From: Ian Stocks [REDACTED] **On Behalf Of** FRS Water and Access
Sent: 22 November 2021 08:55
To: Planning.Responses <Planning.Responses@arun.gov.uk>
Subject: RE: Planning Consultation on: BN/139/21/DOC

Application No: BN/139/21/DOC

Site Address: GTR (Global Technologies Racing Ltd) Land South of Arundel Road Fontwell
Arundel BN18 0SB

Description of Works: Approval of details reserved by condition imposed under ref BN/18/21/RES
relating to Condition No 2 - proposed location of 1 No. fire hydrant or stored
water supply.

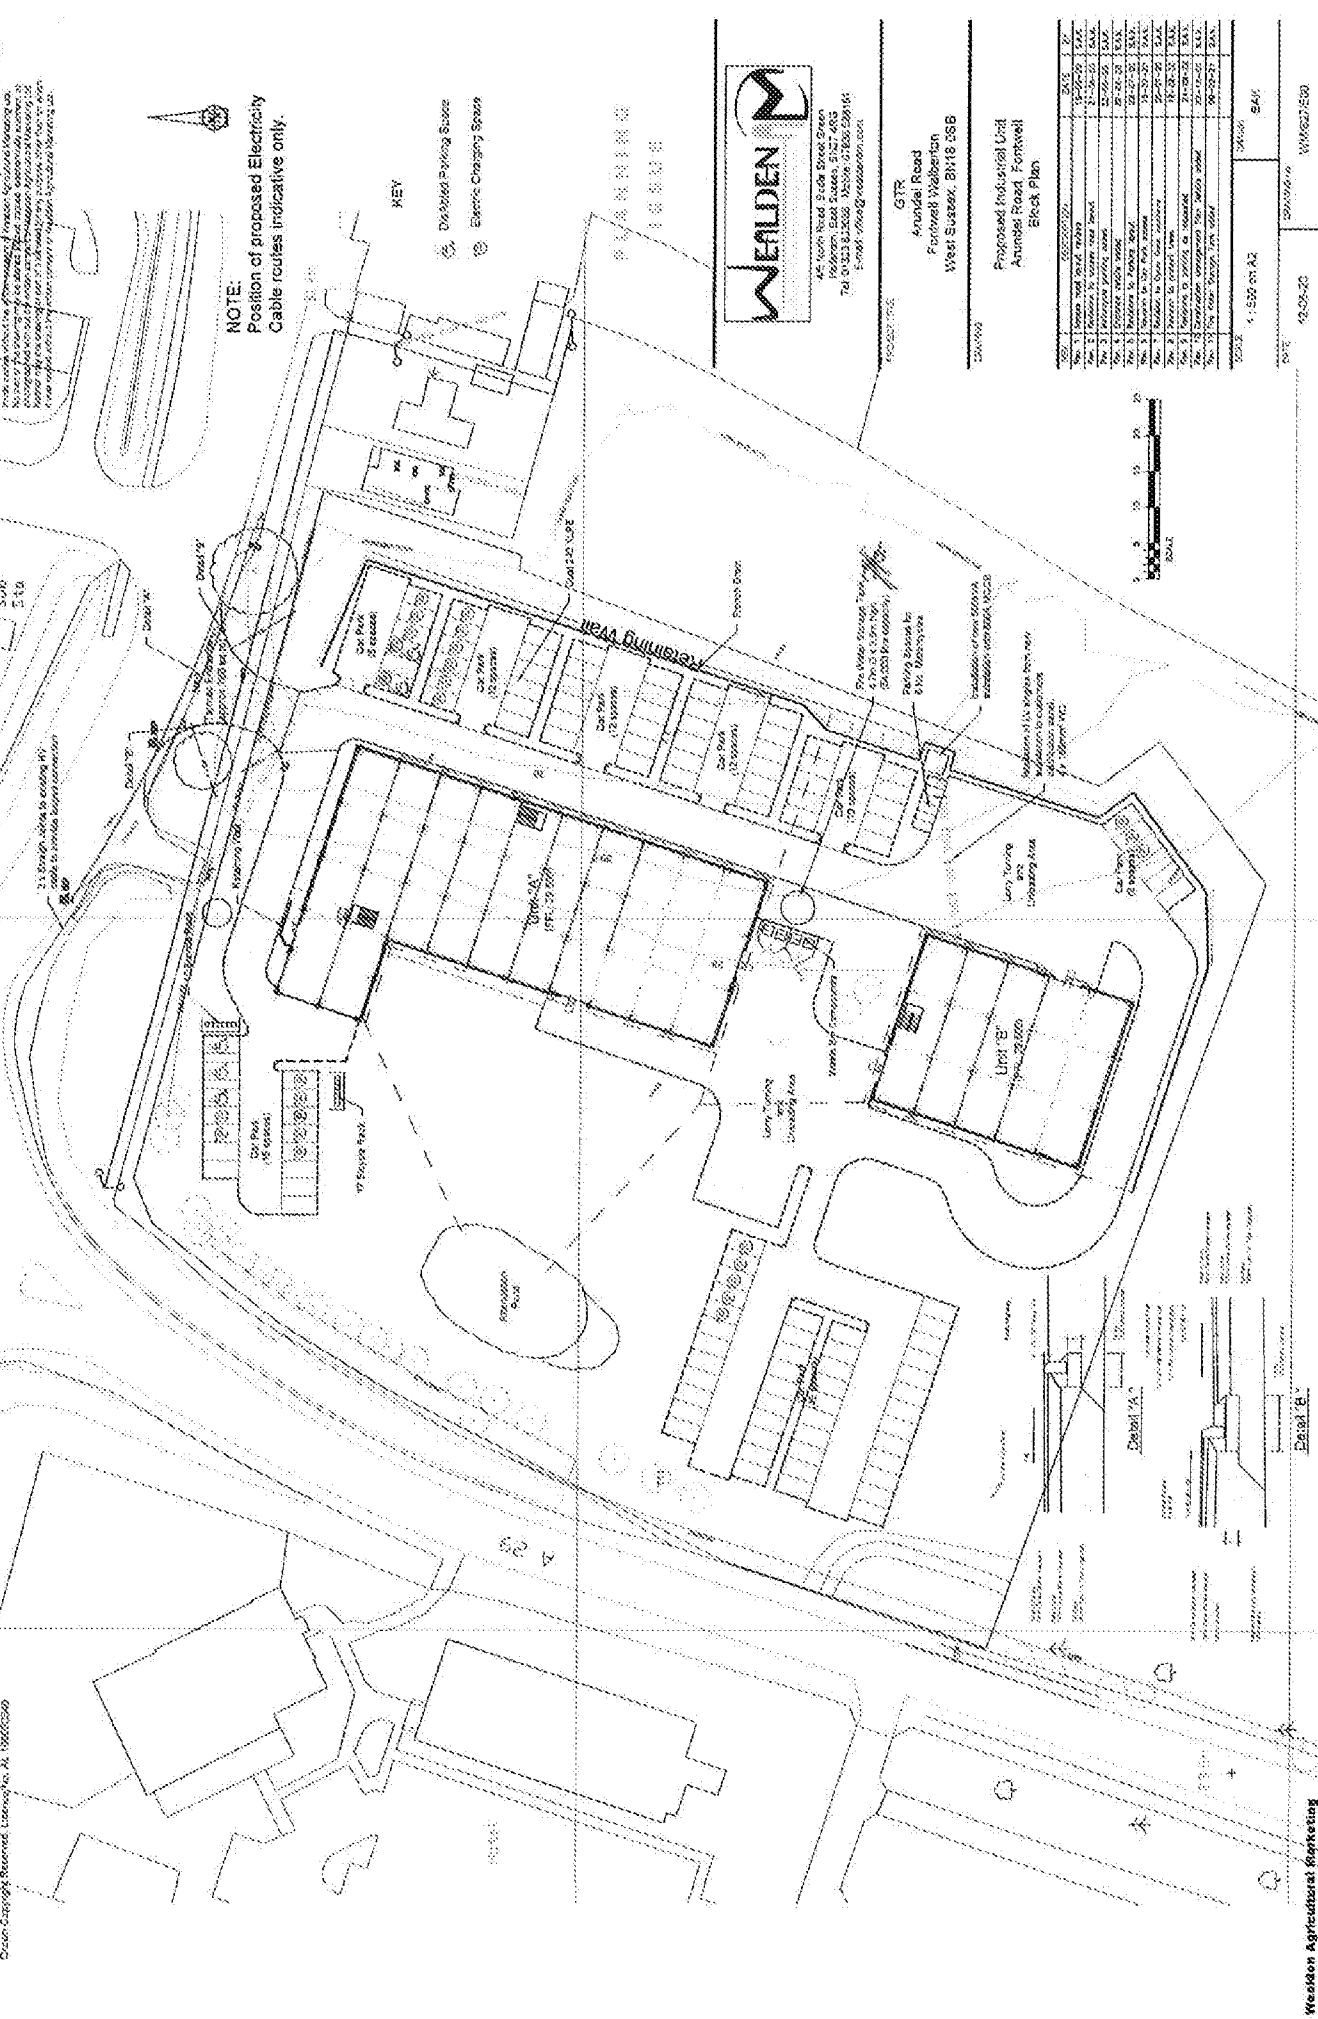
The provision and installation of a 54,000 litre stored water facility for firefighting would meet with the requirements for an alternative water supply for firefighting and be acceptable by west Sussex Fire and Rescue Service. The plans indicate there is a hard standing area within 10 metres of the storage tank to give the fire appliance access.

What I would request is fitting a 4" British BSRT connection to the storage tank, this will enable us to connect our hard wall suction hoses and be able to suck the water out using equipment on the fire appliance rather than relying on gravity feed that would give much less supply and may not keep the fire appliance supplied with water whilst firefighting.
